9th August 2021

Application No: LU/221/21/HH
Site Address: 14 Mariners Quay Littlehampton BN17 5DA
Description of works: Conversion of roofspace to habitable use to include 4 x rooflight.

Thank you for your internet representation made on 7th August 2021 which has been recorded as no objection with the comments as follows:

DRAWING PROPOSED FRONT & SIDE ELEVATIONS			
SCALE @ A3	DATE	DWG No	REVISION
1:100	JULY 2021	WPD621/H/14	B

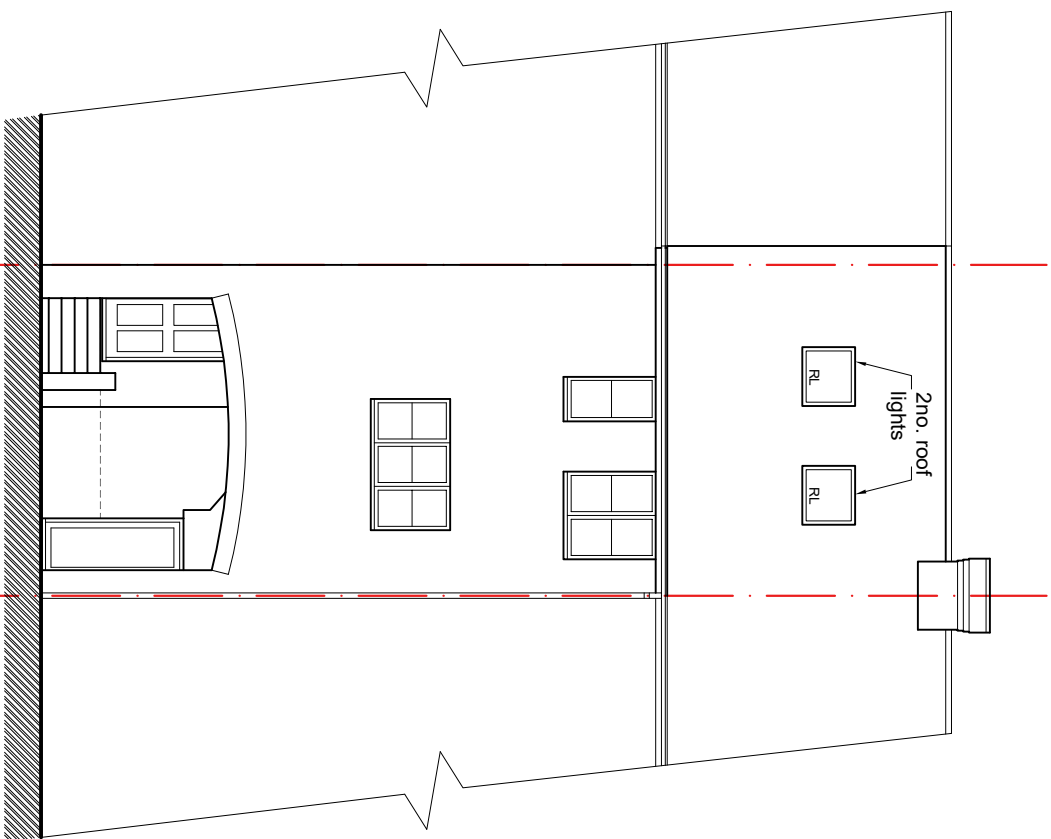
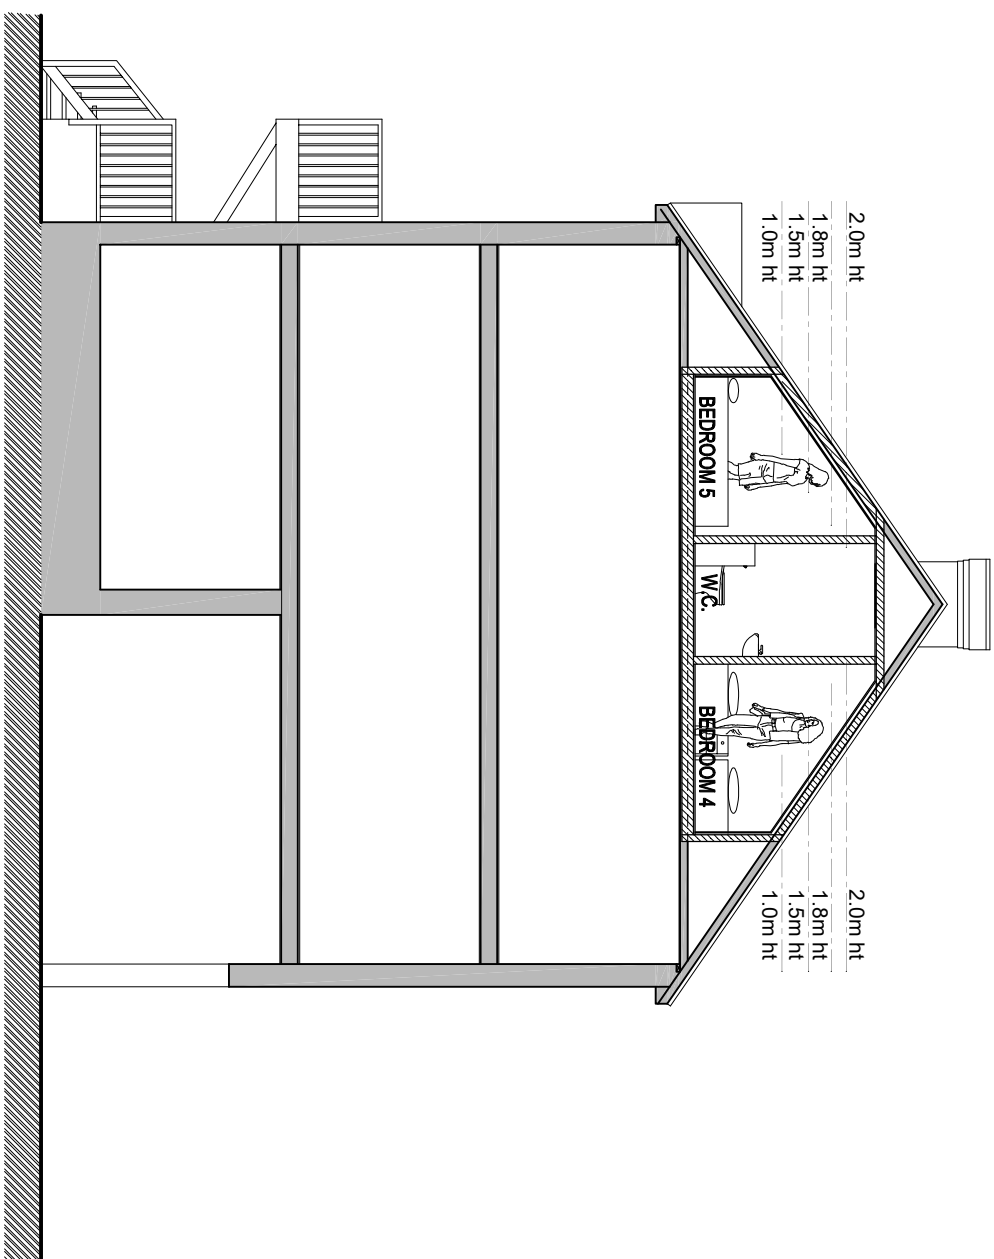
In this case the proposed application appears not to do this. The bifold doors appear to be in keeping with the fenestrations that currently exist ie four panes of glass and are not significantly different therefore as long as steps are taken to ensure the bifold doors match the existing fenestration it would appear that this should not be an issue.

again conversion of the loft space was also being completed. This application was approved with the recommendation from the conservation officer that conservation windows should be used. I understand this was a requirement that was made which once again shows the importance of preserving this development and its contribution to the street scene. Perhaps consideration needs to be given to this being a similar condition in this case.
